KITTITAS COUNTY DEPARTMENT OF PUBLIC WORKS

MEMORANDUM

SUBJECT: DRAFT: Jett SP-11-00004

JETT SHORT PLAT

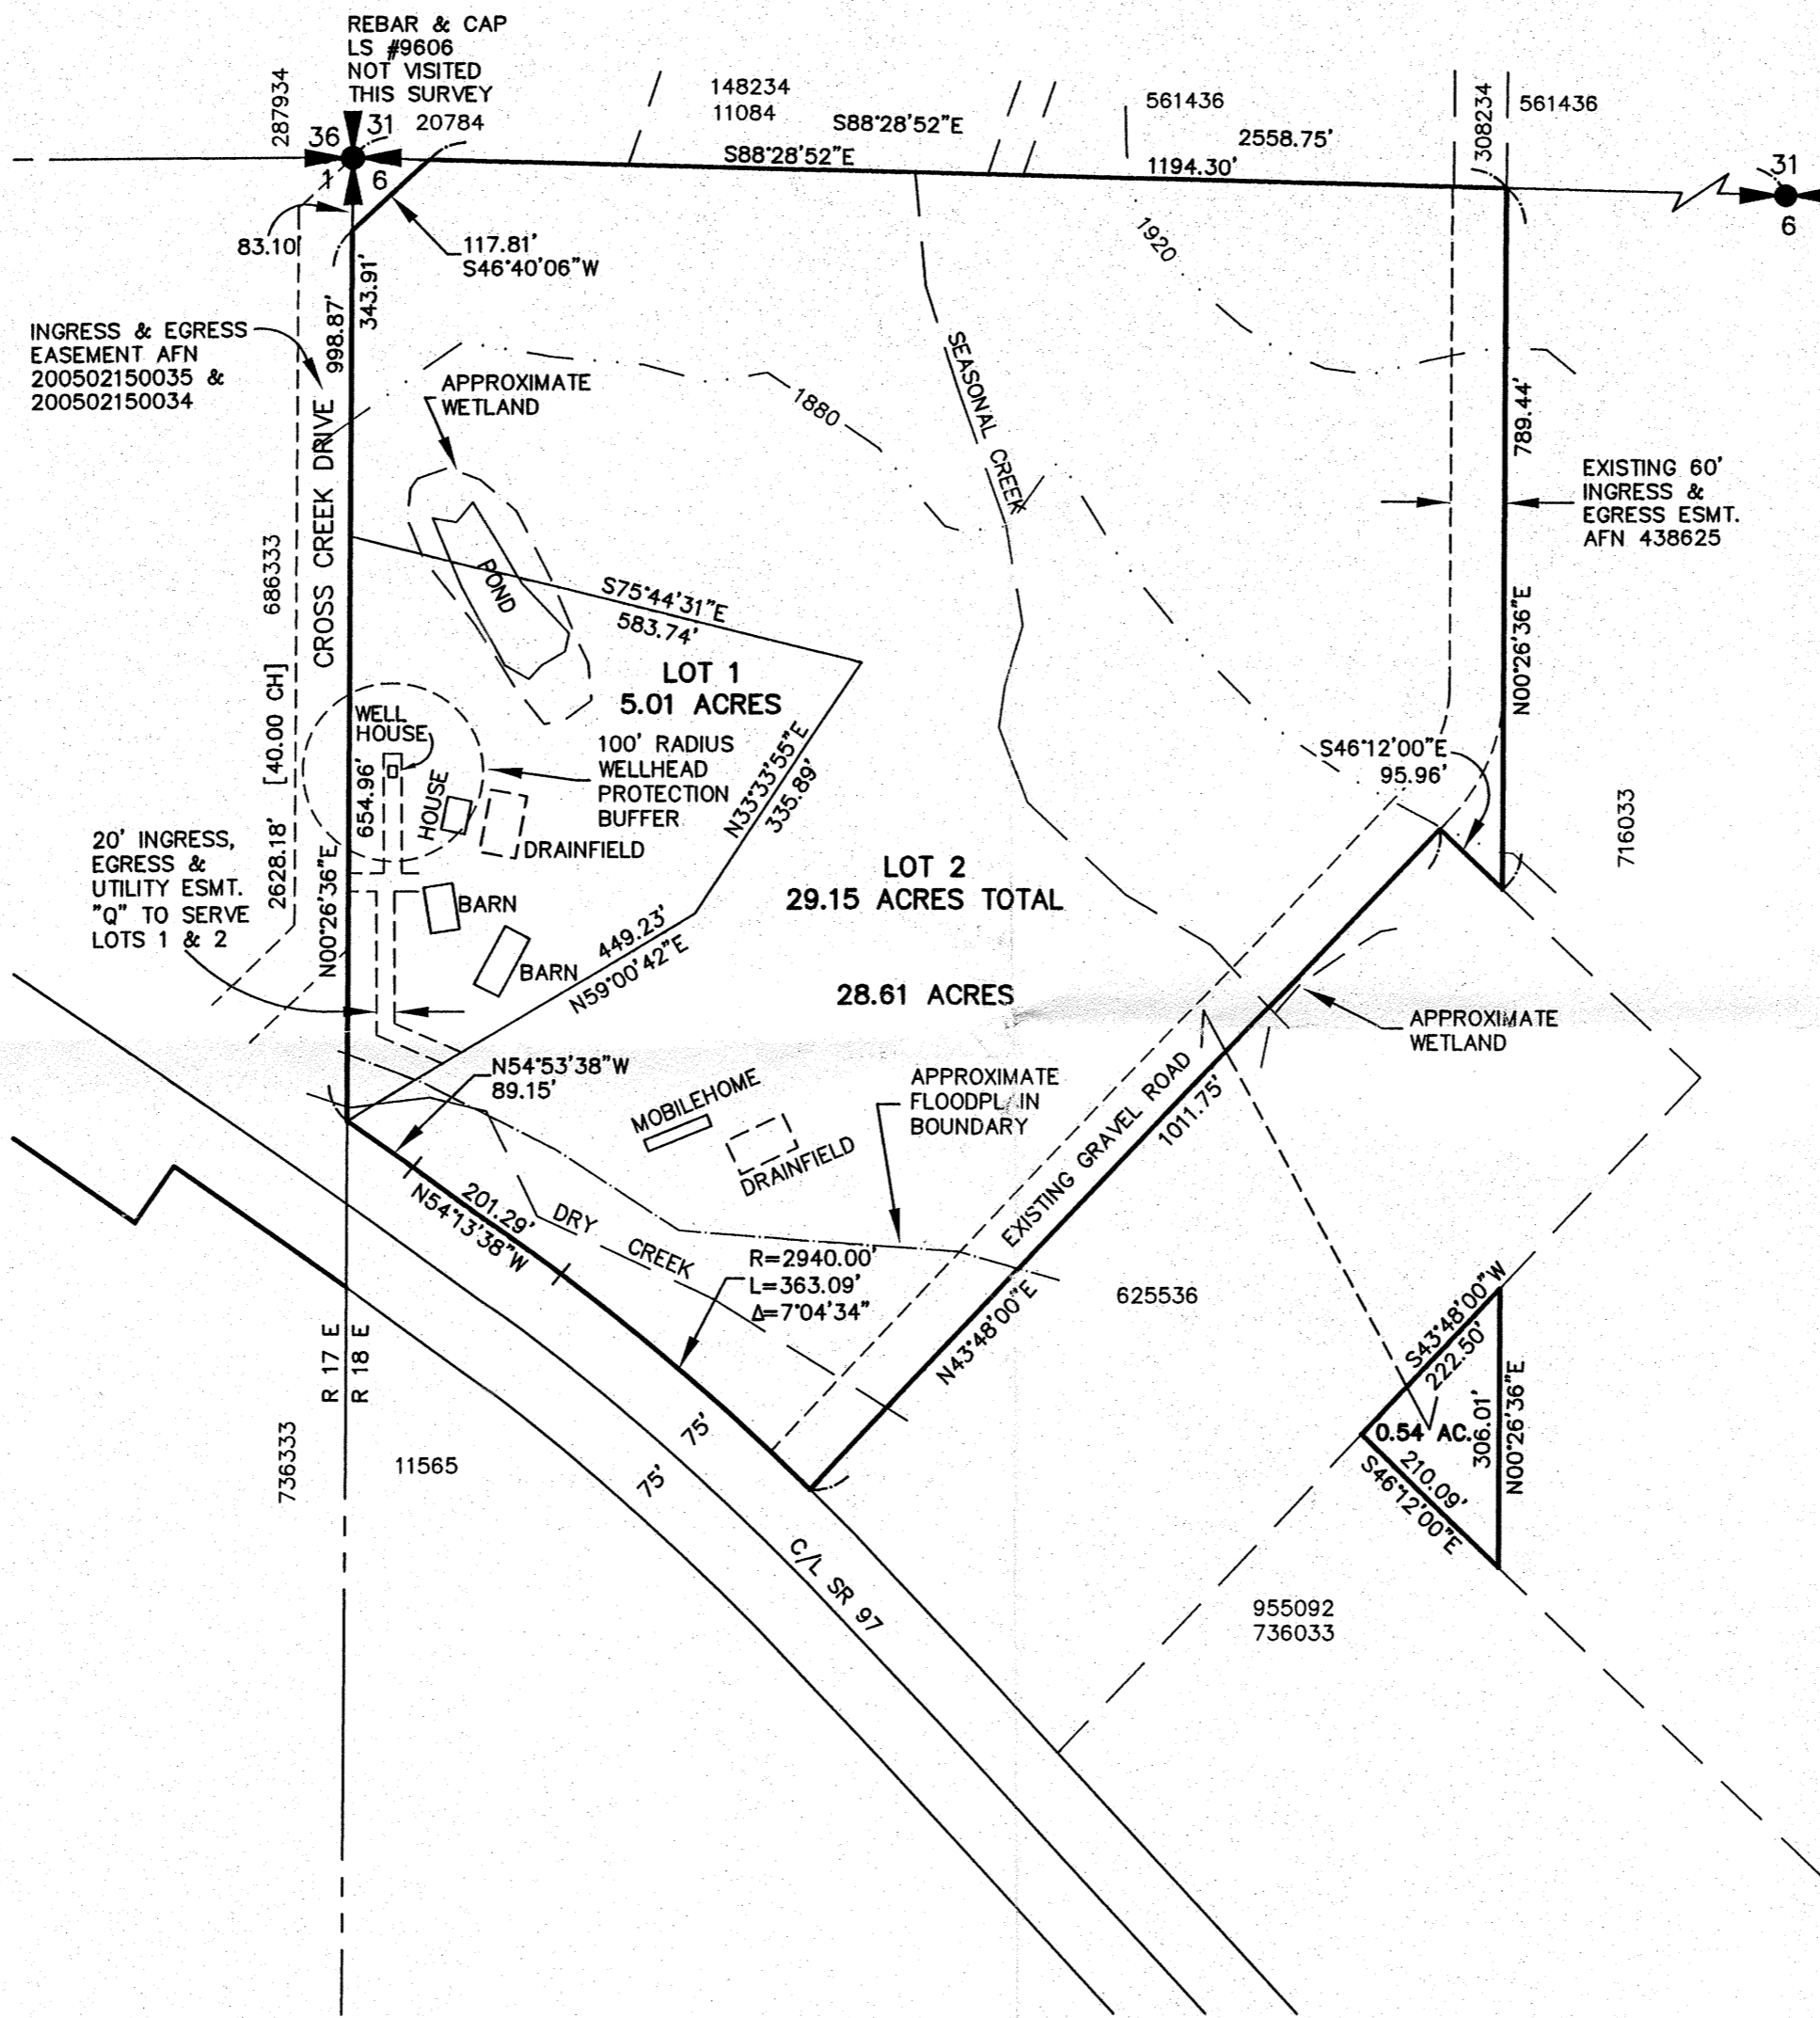
- Increase the road width to 22-feet from US 97 to the entrance to the plat.
 - Construct a hammerhead turnaround at the entrance to the plat.
 - Increase the crossing over Dry Creek to 20-feet in width.

3. Easement Width: The easement width of Cross Creek Drive shall be shown on the final plat.
 4. Private Road Improvements: Access from US 97 to the entrance to the plat shall be constructed as a Low-Density Private Road. See Kittitas County Road Standards, 9/6/05 edition.

- a. Access easements shall be a minimum of 60' wide. The roadway shall have a minimum width of 20', with 1' shoulders, for a total width of 22'.

5. Emergency Turnaround: A hammerhead turnaround shall be constructed on Cross Creek Drive at the entrance to the plat. The hammerhead must conform to the requirements specified by the 2009 International Fire Code. Contact the Fire Marshal regarding any additional cul-de-sac requirements.
